Your Ref: MP 08_0080 MOD 1
Our Ref: D18/5995
DA18062013585 BS

27 June 2018

Part 3A/State Significant Development Application - Modification Of Project Approval - Lyons Road, North Bonville

ROAD PROFILE 5

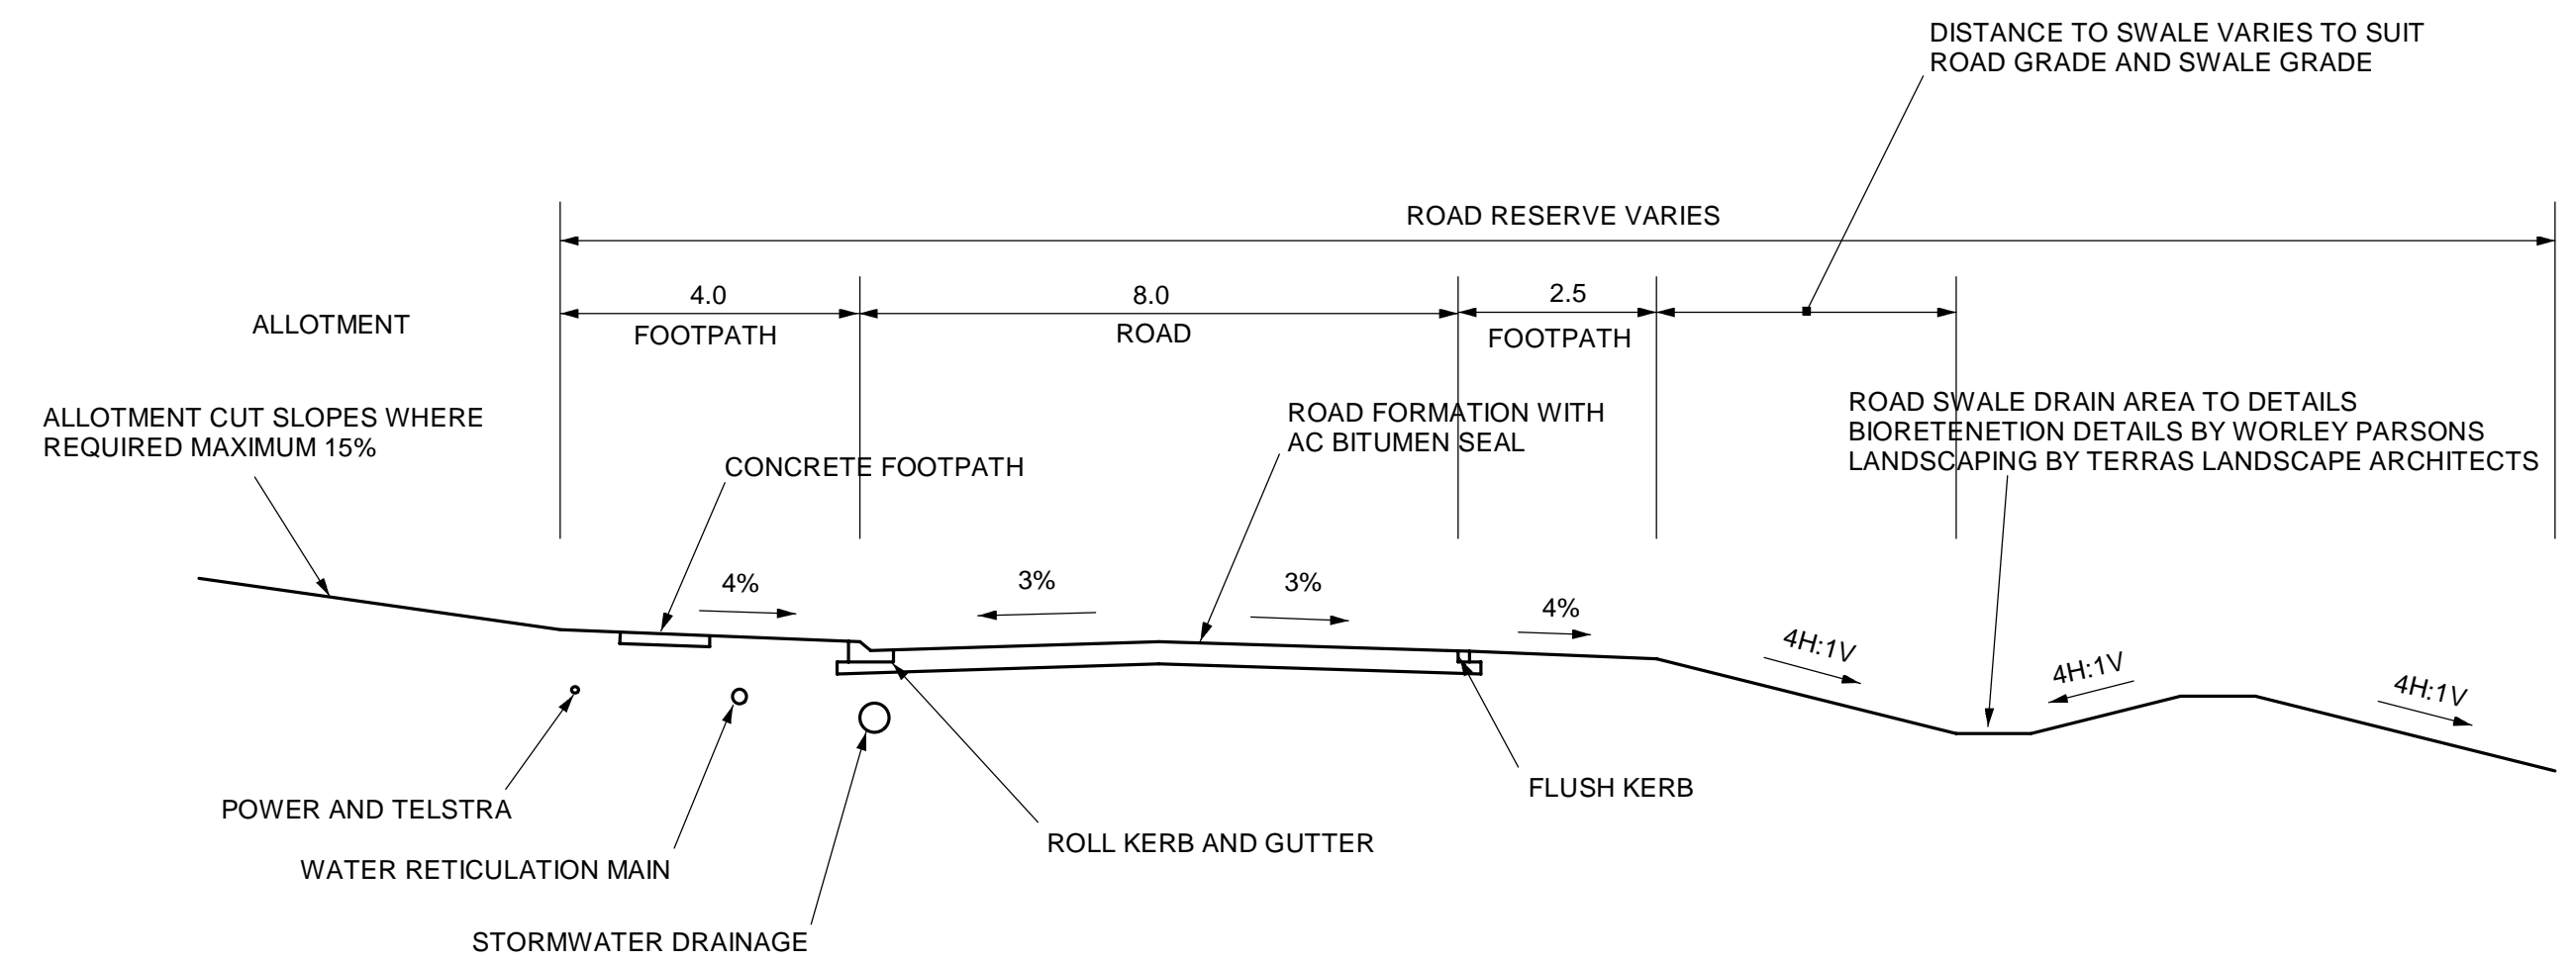
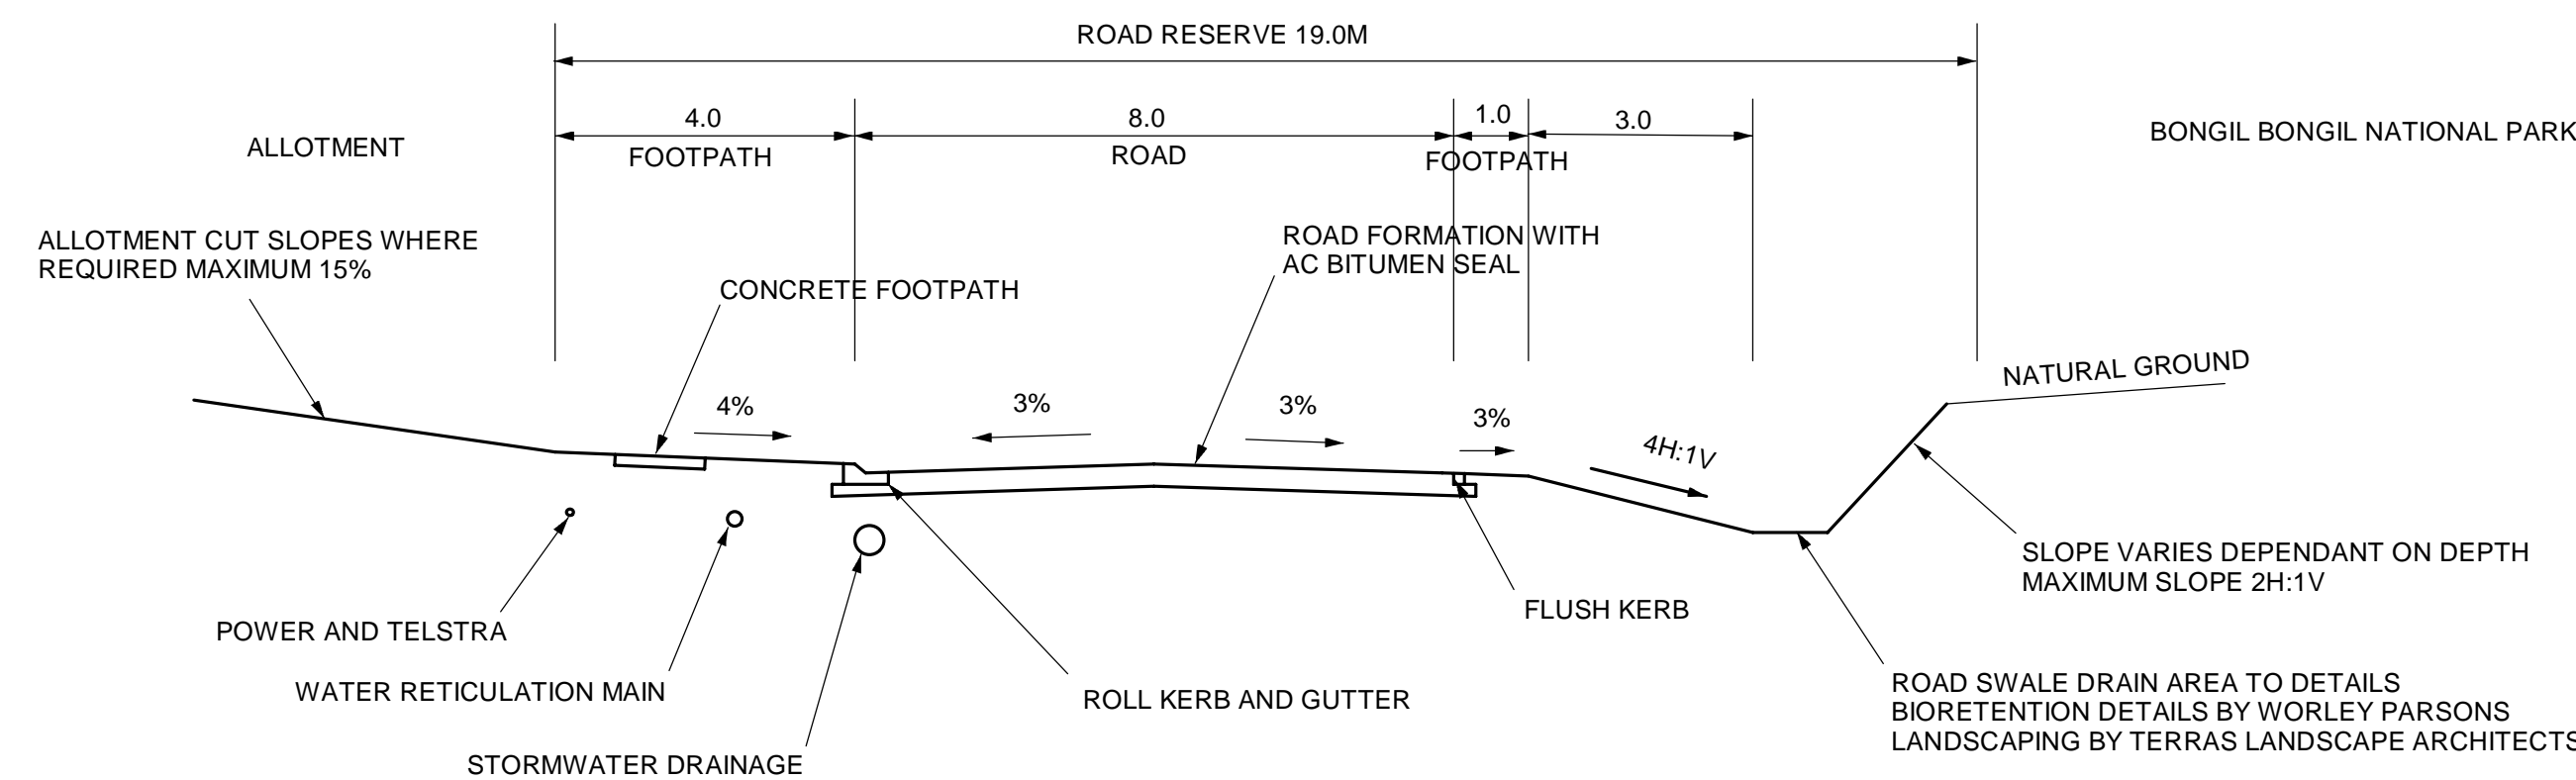
7. Public Road Access shall comply with section 4.1.3 (1) of Planning for Bush Fire Protection 2006.
8. Perimeter roads shall have a minimum carriageway width of 8 metres.

9. Non perimeter road widths shall comply with Table 4.1 in Planning for Bush Fire Protection 2006.
10. The fire trail system is to be connected to the public road system at frequent intervals of 200 metres or less.
